## **Development Facilitation Team (DFT) – Review Comments**

**DRB Project No: PR-2020-003484 Date: 11/13/2024 Agenda Item: #5 Zone Atlas Page: E-10**

**Request: Replat of Lots 2 and 3 – create 19 lots from the existing tracts.**

### **Application For: SD-2024-00158 – EXTENSION OF PRELIMINARY PLAT (DHO)**

PRELIMINARY PLAT FOR
MOJAVE RIDGE SUBDIVISION
 (A REPLAT OF LOTS 2 & 3, BLOCK 12,
 UNIT 3, VOLCANO CLIFFS SUBDIVISION)
 WITHIN
 SECTION 27,
 TOWNSHIP 11 NORTH, RANGE 2 EAST, N.M.P.M.
 CITY OF ALBUQUERQUE
 BERNALILLO COUNTY, NEW MEXICO
 JANUARY, 2023

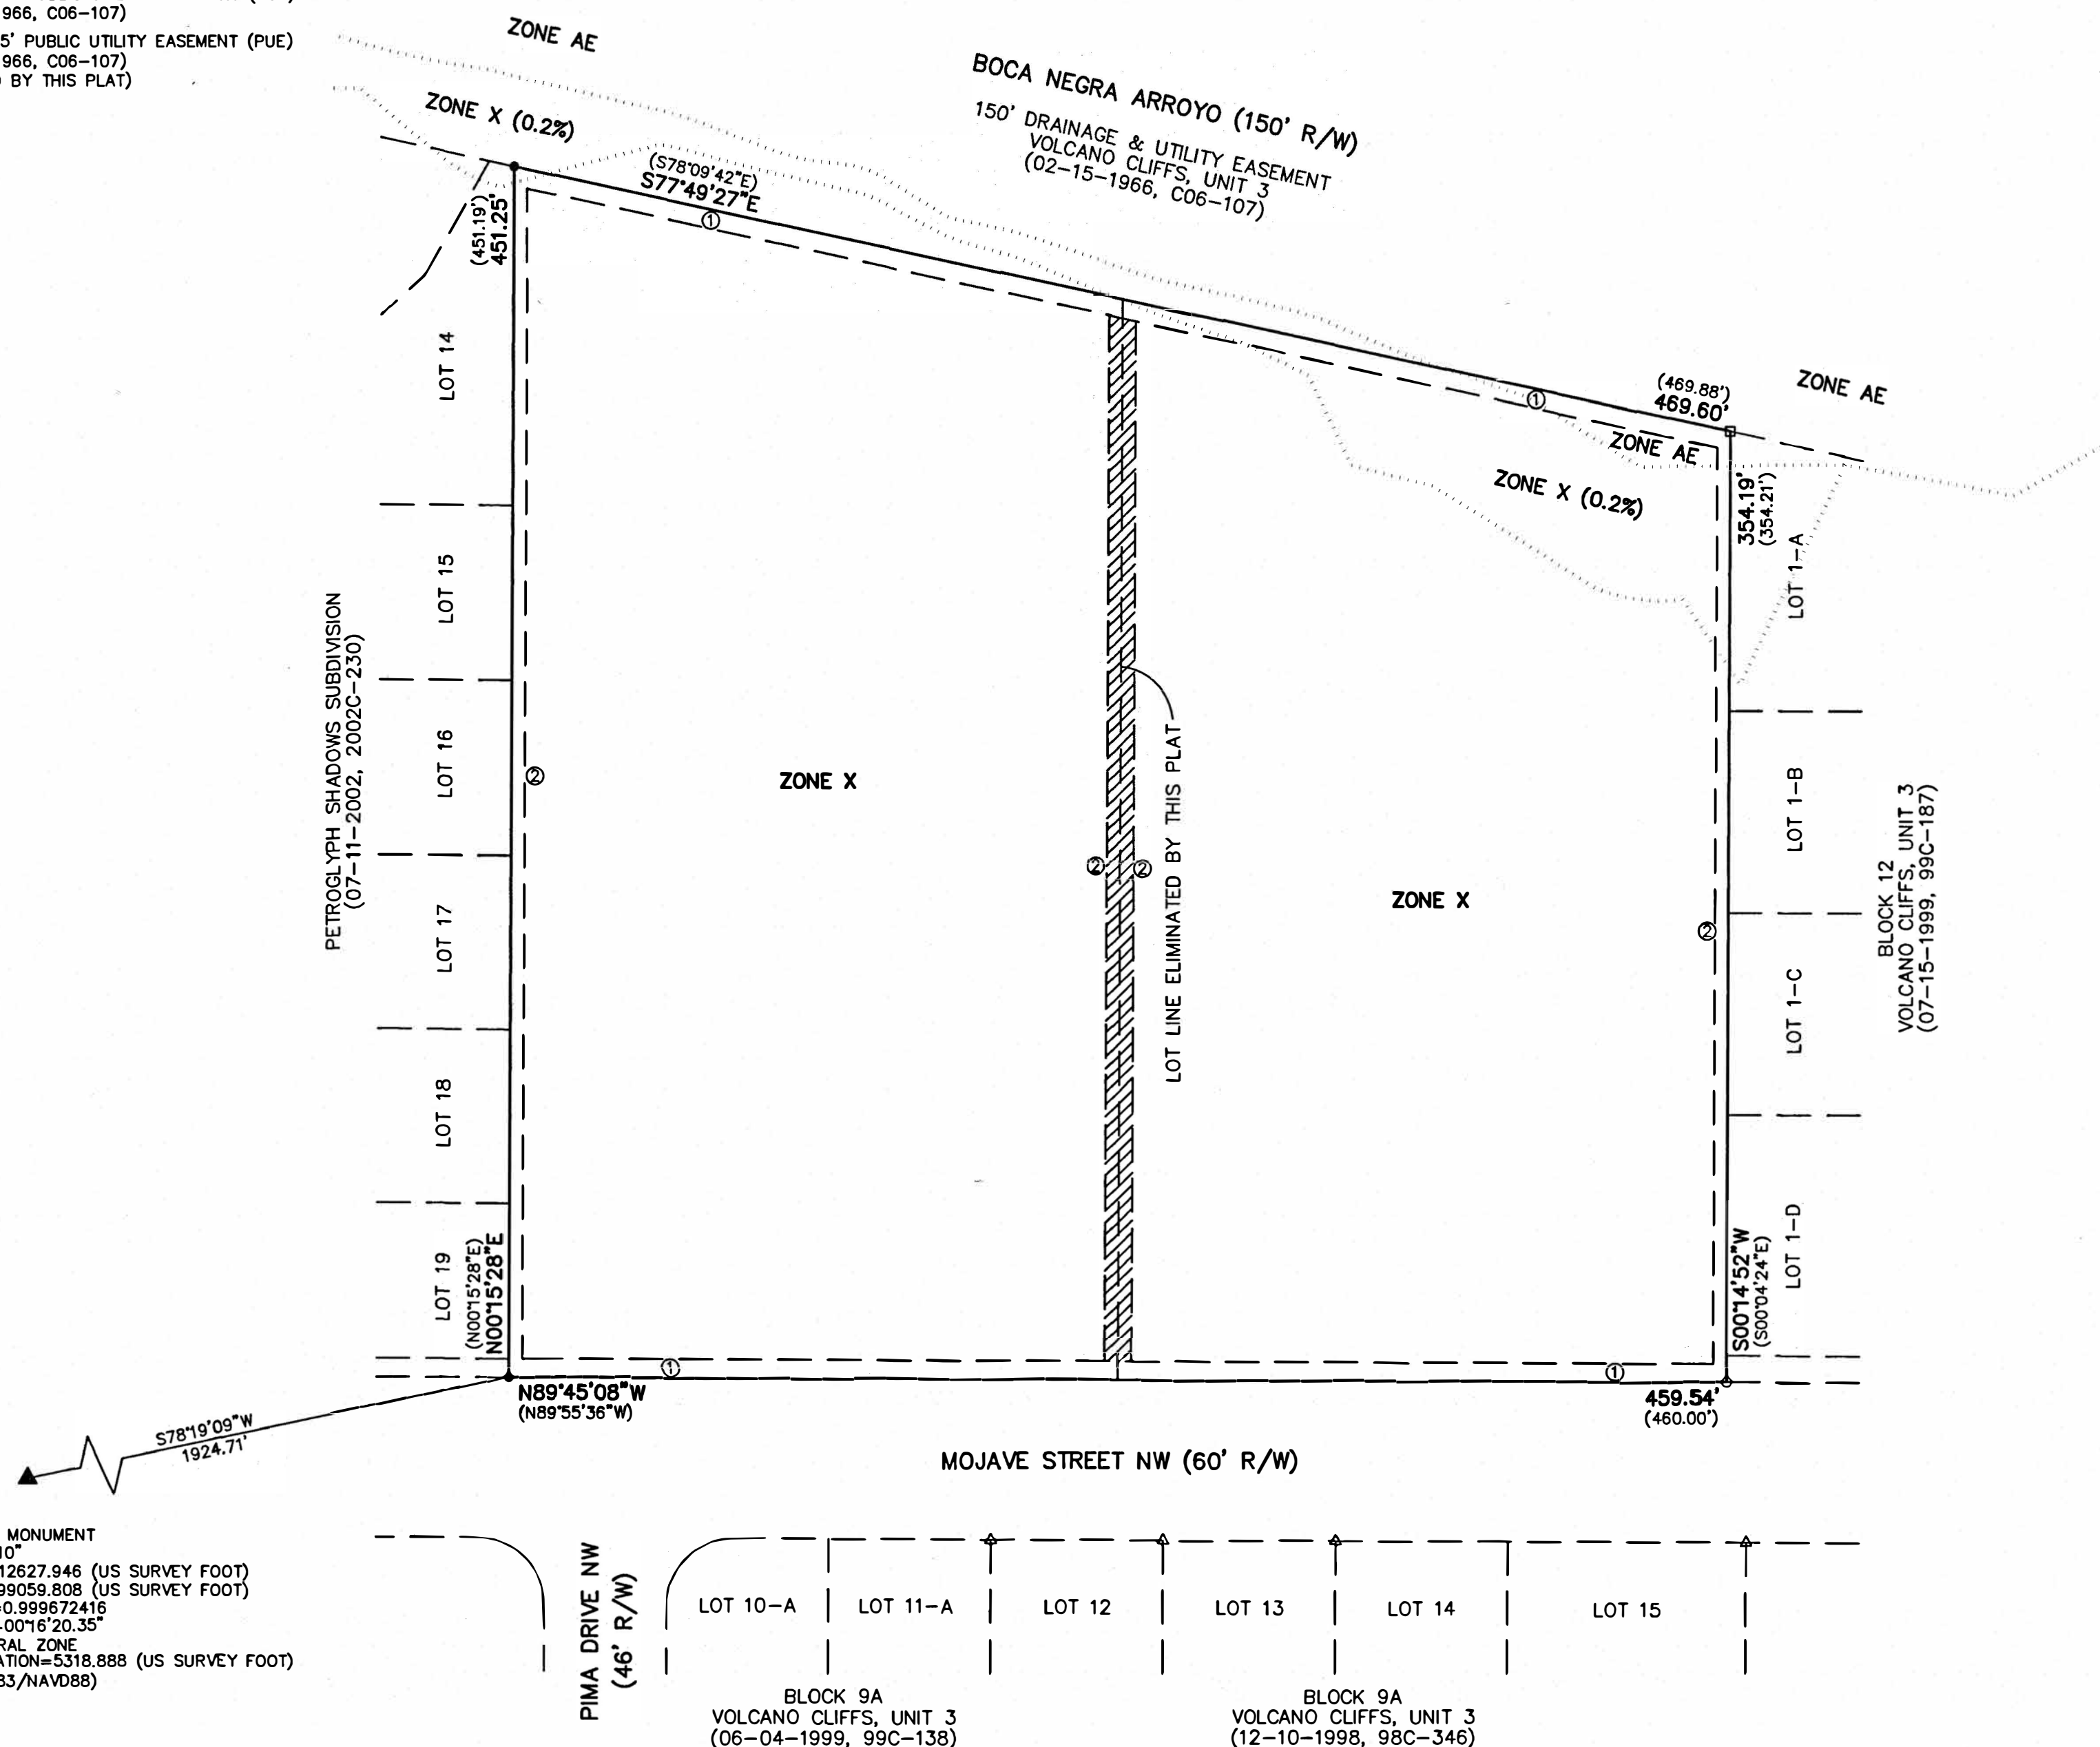
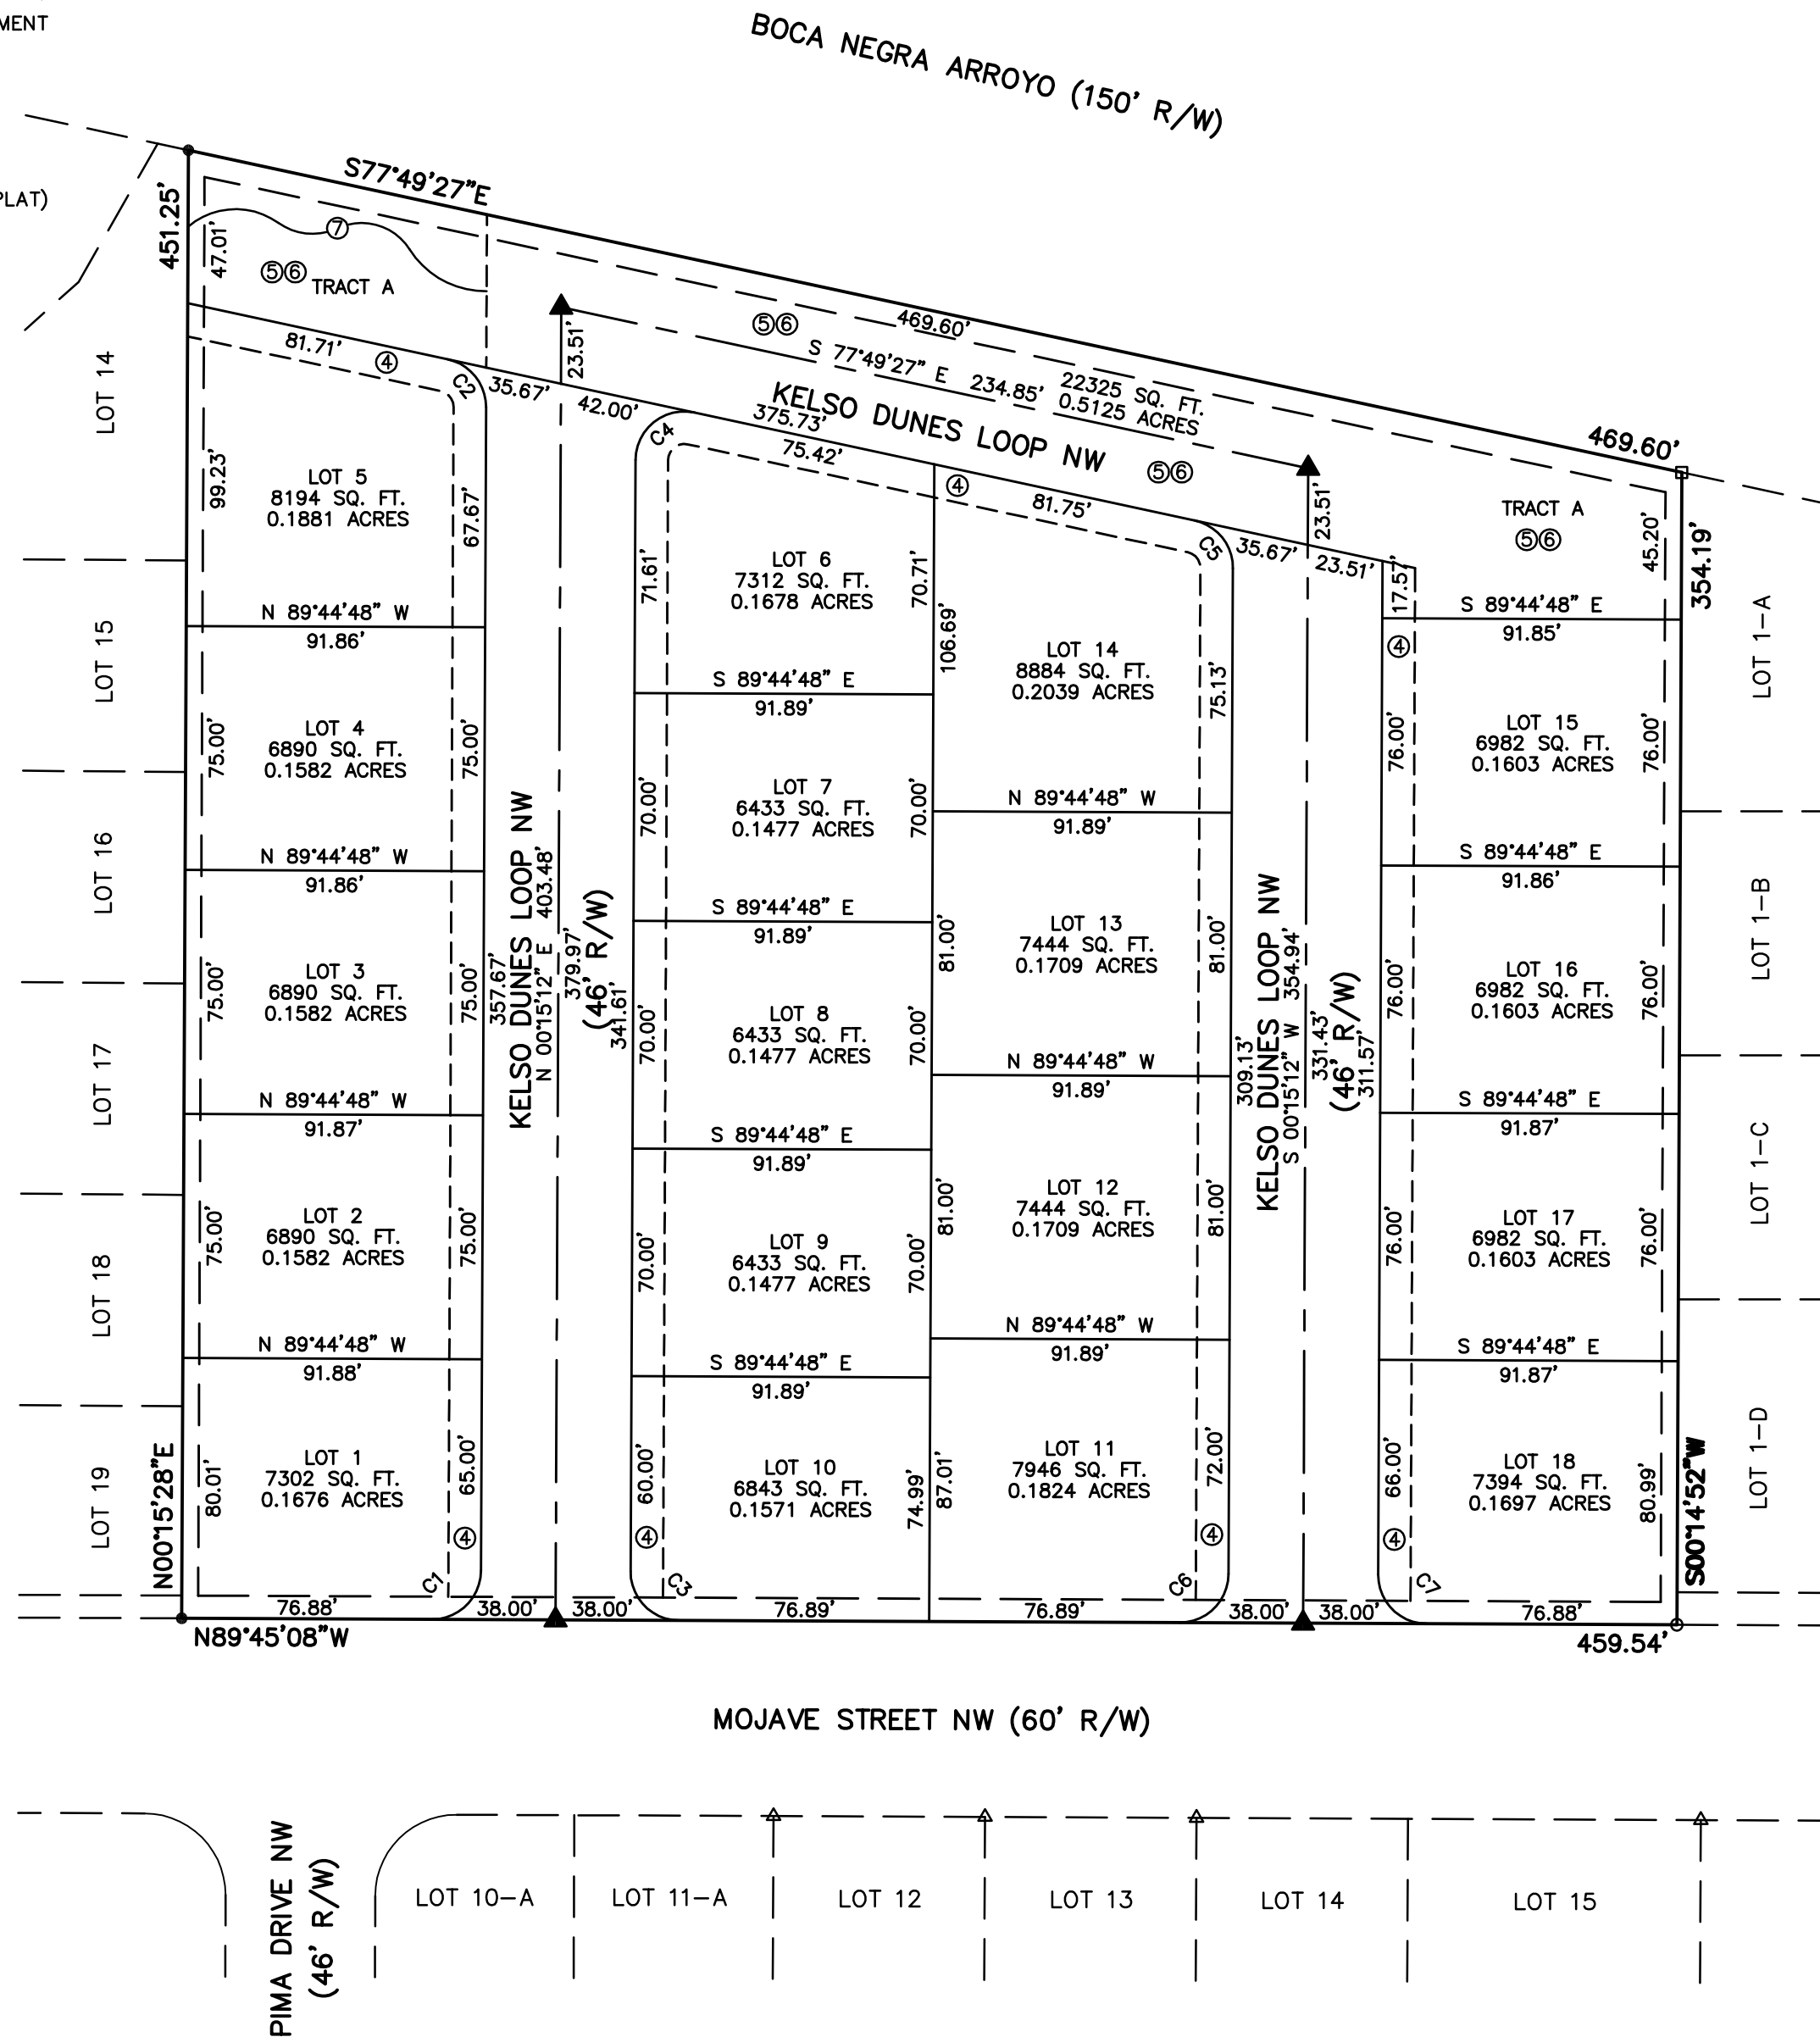
Please note on the plat that the Boca Negra Arroyo parcel is zoned NR-PO-B Major Public Open Space/Petroglyph National Monument. This helps staff identify standards that will be required when the site is developed.

Please note on the plat the **45' landscape buffer** required on Tract A due to adjacency to MPOS – No development is allowed and plant species and location must be approved by the Open Space Superintendent.

Per Parks and Recreation: Add note on the plat that the parcel adjacent to the subject site "Boca Negra Arroyo (150' R/W)" is zoned NR-PO-B for MAJOR PUBLIC OPEN SPACE - PETROGLYPH NATIONAL MONUMENT.

Per Planning: Revise the Infrastructure List Notes on Drainage to state 'City Standard Specification 1013.' Add a note to the Plat indicating DHO approval of the determination to retain a 60-foot Right-of-Way on Mojave Street.
